CITY OF ALBUQUERQUE

**RE: Mister Car Wash
2161 Gibson Blvd SE
Grading & Drainage Plan
Engineer's Stamp Date: 11/17/22
Hydrology File: M15D021B**

Based upon the information provided in your submittal received 01/17/2023, the Grading & Drainage Plan is approved for Building Permit and Grading Permit. Please attach a copy of this approved plan in the construction sets for Building Permit processing along with a copy of this letter.

COMMENT RESPONSE LETTER

SHEET NUMBER
C601

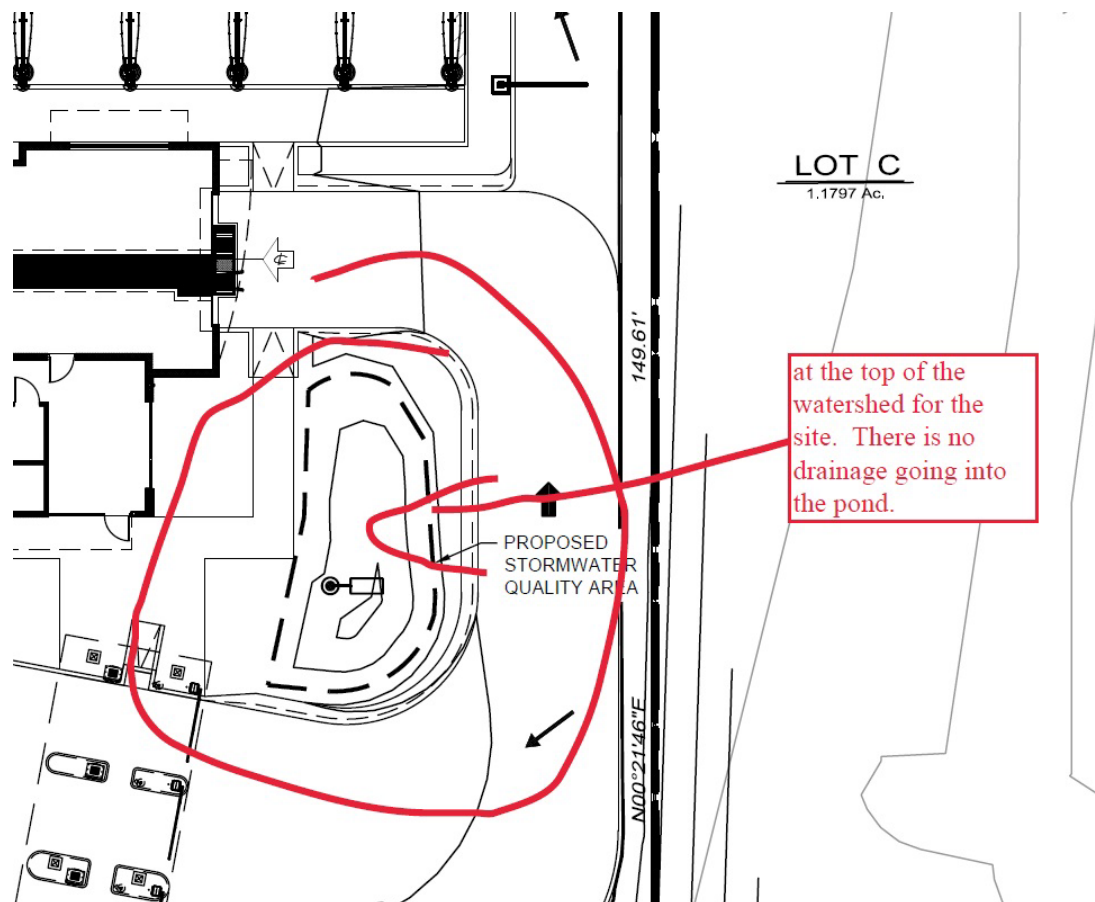
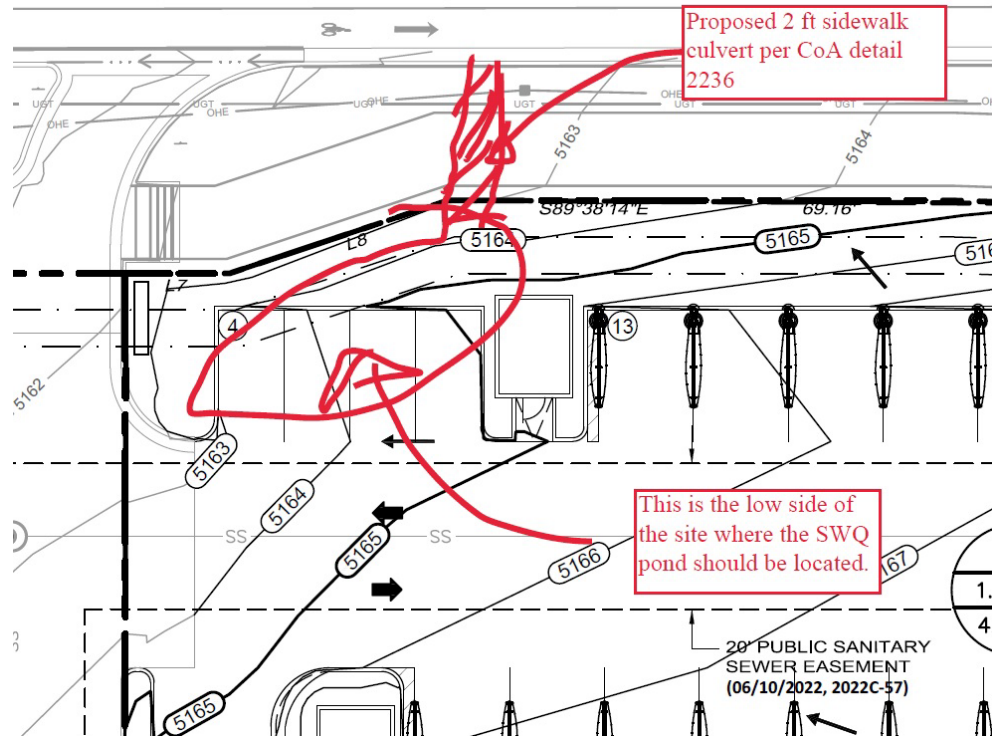
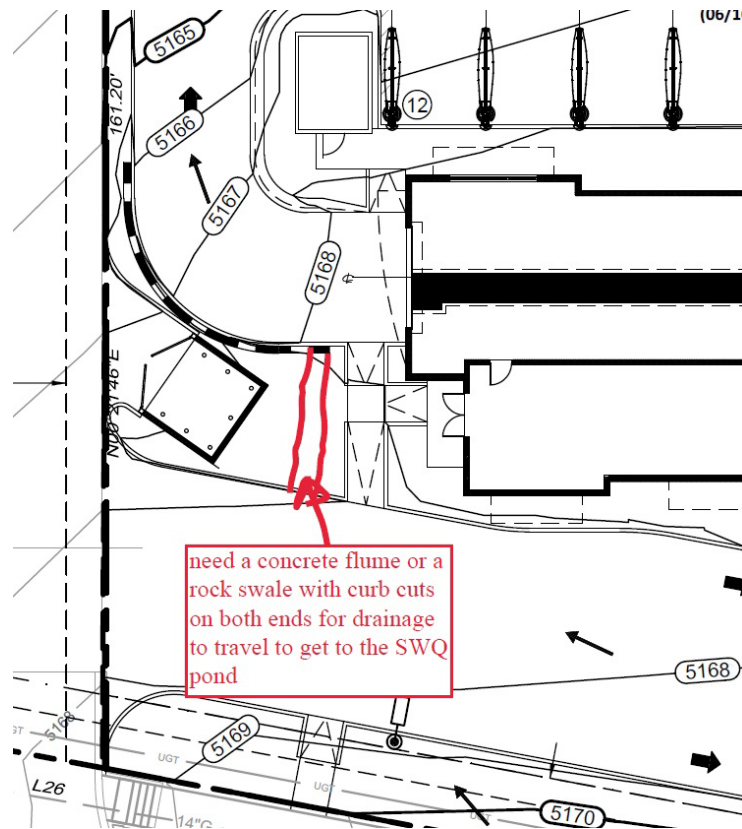
4. Please use the procedure for 40 acre and smaller basins as outlined in Development Process Manual (DPM) Article 6-2(a). Please provide both the existing conditions and proposed conditions for the 100 year-6 hour storm event.

5. Provide management onsite for the Stormwater Quality Volume (SWQV) in accordance with the Drainage Ordinance, § 14-5-2-6 (H) and the DPM Article 6-12 Stormwater Quality and Low-Impact Development for the sizing calculations. To calculate the required SWQV, multiply the impervious area draining to the SWQ pond by 0.42 inches for new development sites. Please show both the required and the provided volume.

6. The onsite drainage should be directed to the stormwater quality (SWQ) pond prior to leaving the site. Currently you have the SWQ pond on the high side of the site with little drainage going into it. Also, please show the top and bottom of the pond along with the volume for the pond. The pond also needs a spillway in the form of a sidewalk culvert at the SWQ water surface elevation on the pond side and match the existing gutter elevation in Gibson.

8. Please add either a concrete flume (channel) or a rock swale with curb cuts on either end so that the drainage can travel to the SWQ pond.

9. Please provide the weir calculations, per DPM Article 6-16(A), for the curb cuts and sidewalk culverts. A coefficient of 2.7 is typically used for the weir equation $Q = CLH^{2/3}$.

Response: Existing and Proposed Condition 100 year – 6 hour flows have been added to the sheet.

Response: As this is a redevelopment site, we have provided the SWQV calculations based on 0.26 inches, and this has been added to the plan sheet.

Response: The SEC of the site and the area adjacent to the east side of the building flows into the SWQ area. The areas to the south and west sides of the building flows across landscape prior entering the paved areas and discharging to Gibson Blvd. There are numerous challenges to providing the SWQ area in the location suggested in the comments due to the sites grading, access drive, and parking demands. Please see attached waiver letter for remaining SWQ volume.

Response: This is the transformer pad location so a flume cannot be provided across the island behind the dumpster.

Response: The drainage sheet flows over the sidewalk or in the driveways to Gibson.
